From: Steve Farrell [redacted]
Sent: 12 September 2018 12:49
To: Daun Johnson
Subject: RE: Planning Application PP-07169759v1

Existing & Proposed part Ground floor plans -Conversion of lounge area to create 8 additional bedrooms
Existing & Proposed part First floor plans - Conversion of rooms 18, 20 and 22 to create 2 additional bedrooms
Existing & Proposed part Second floor plans - Conversion of rooms 48 and 50 to create 1 additional bedroom
Existing & Proposed part Staff area plans – Additional external door opening created and internal opening blocked off
Design and Access Statement
Block plan at 1:500
Location plan 1:1250
Heritage statement
Listing information.

ROYAL NORFOLK HOTEL – PROPOSED PART GROUND FLOOR PLAN SCALE 1:100 AT A3

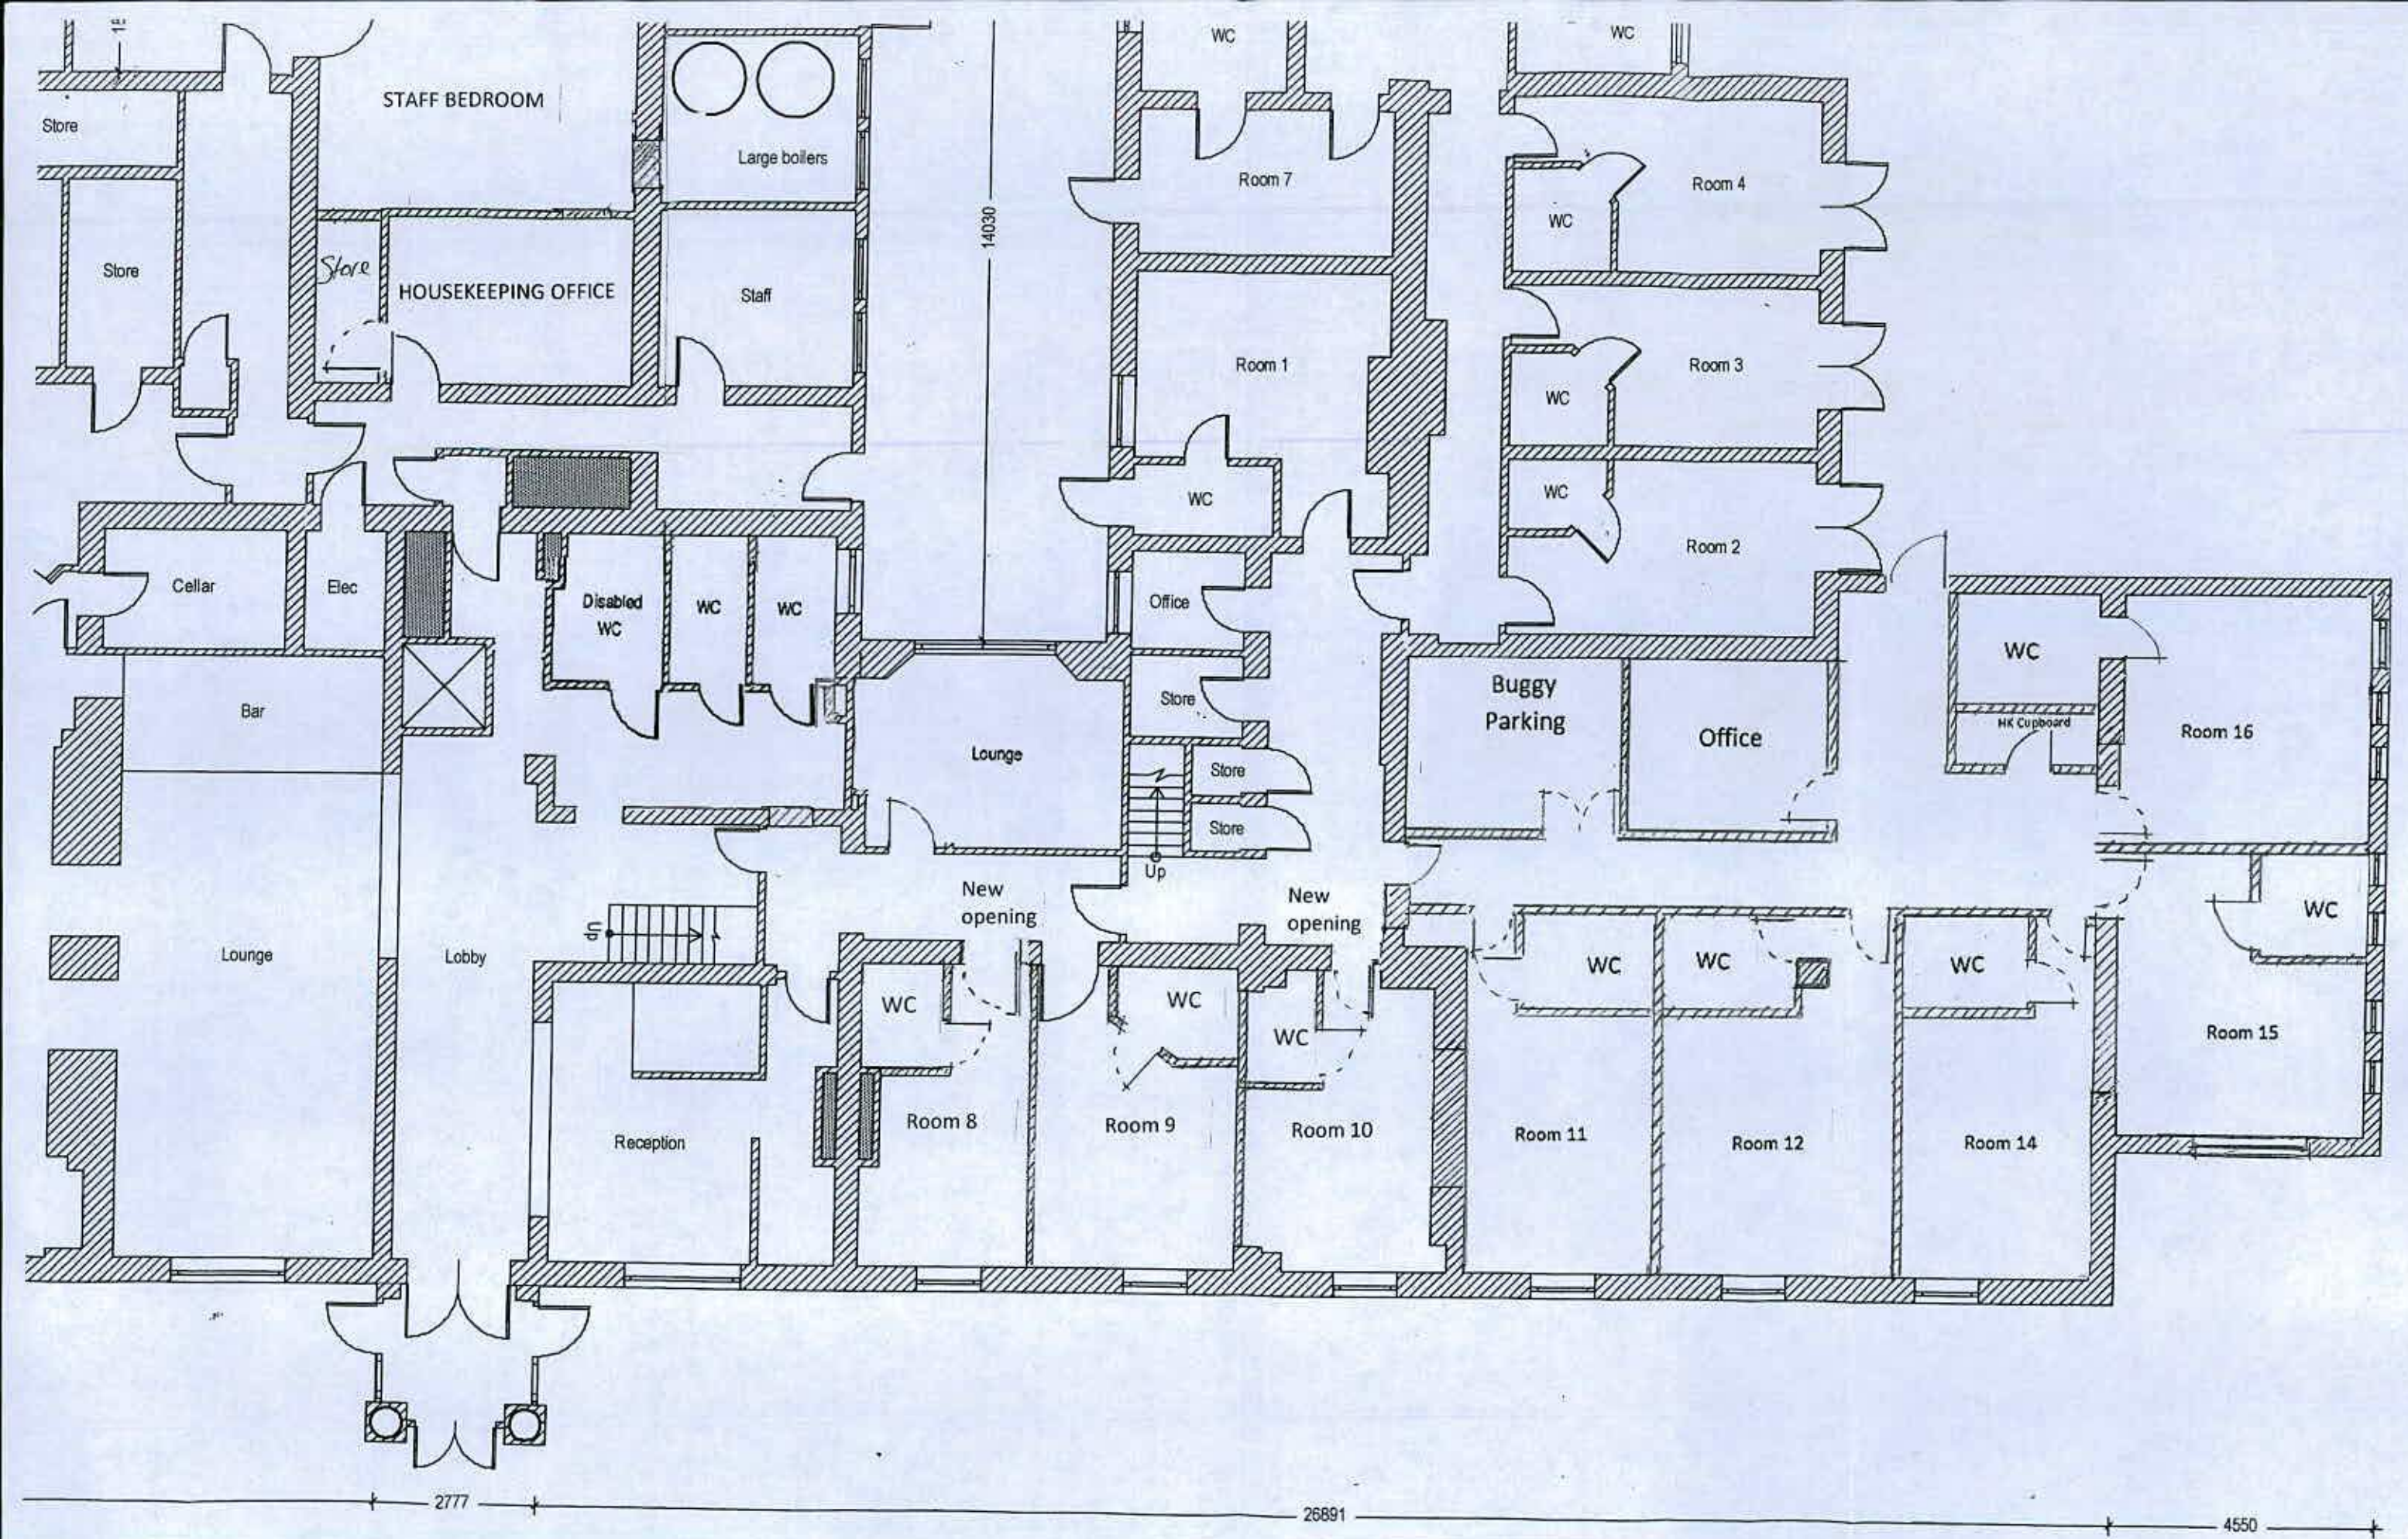
I have looked at the plans and I have noticed that the floor plans, both existing and proposed, are not to scale.

When I printed them, the legend indicates the paper size of A3 at a scale of 1:100 whilst the floor plans have been sent as an A4. Please resend the existing and proposed floor plans to me so they scale properly.

I think it best that I send scaled paper copies via the post, I assume you will need 3 copies? I will enclose the elevations requested at the same time which will be next week now. There are 11 new bedrooms proposed as follows;

EXISTING WEST ELEVATION TO STAFF ROOMS SCALE 1:50 @ A3

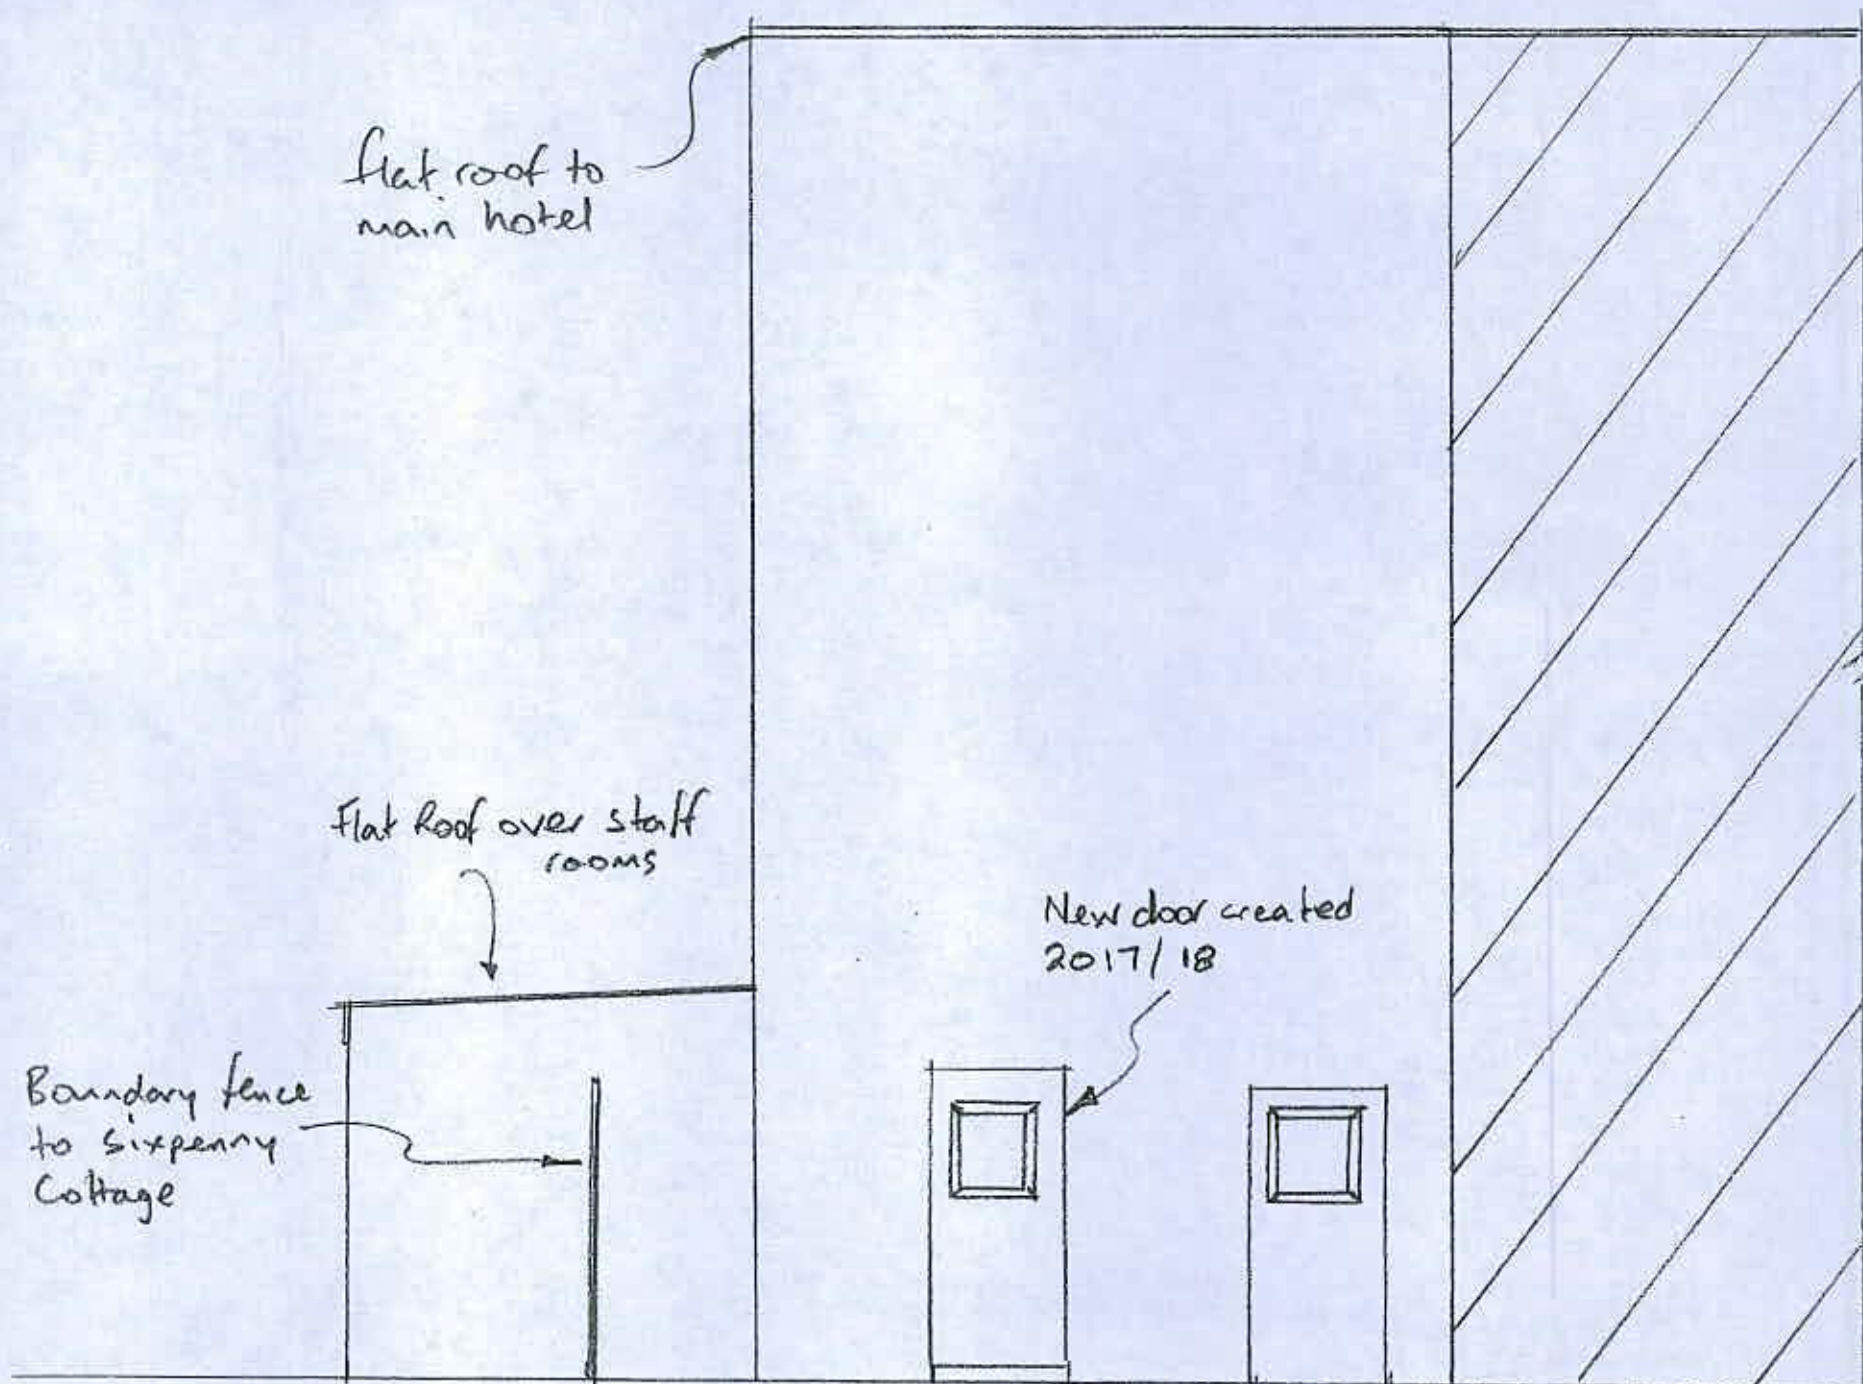
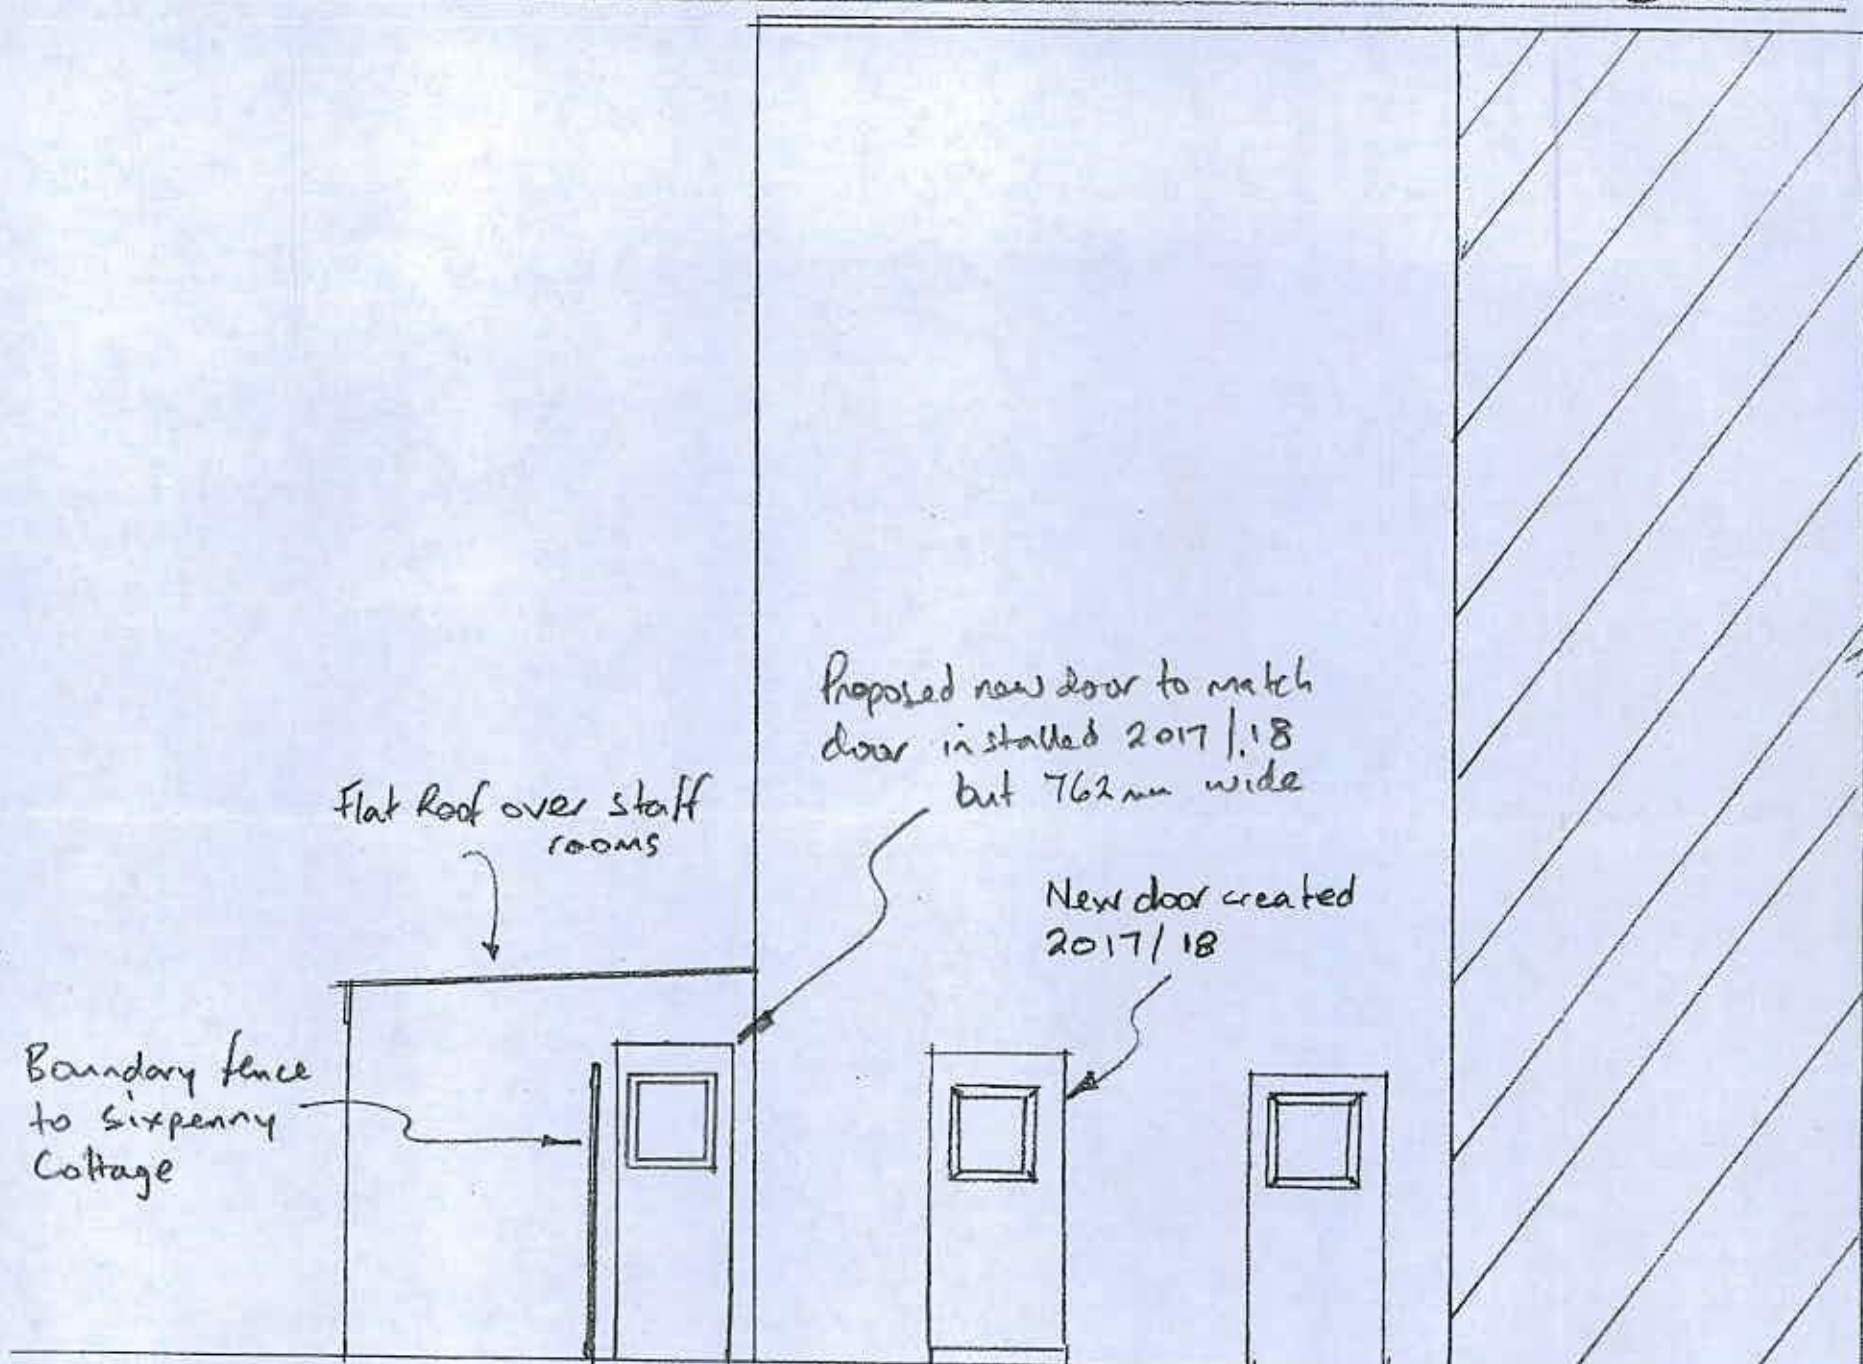
Please confirm the number of new bedrooms and I will also need an existing and proposed elevation showing the proposed door in the staff bedroom.
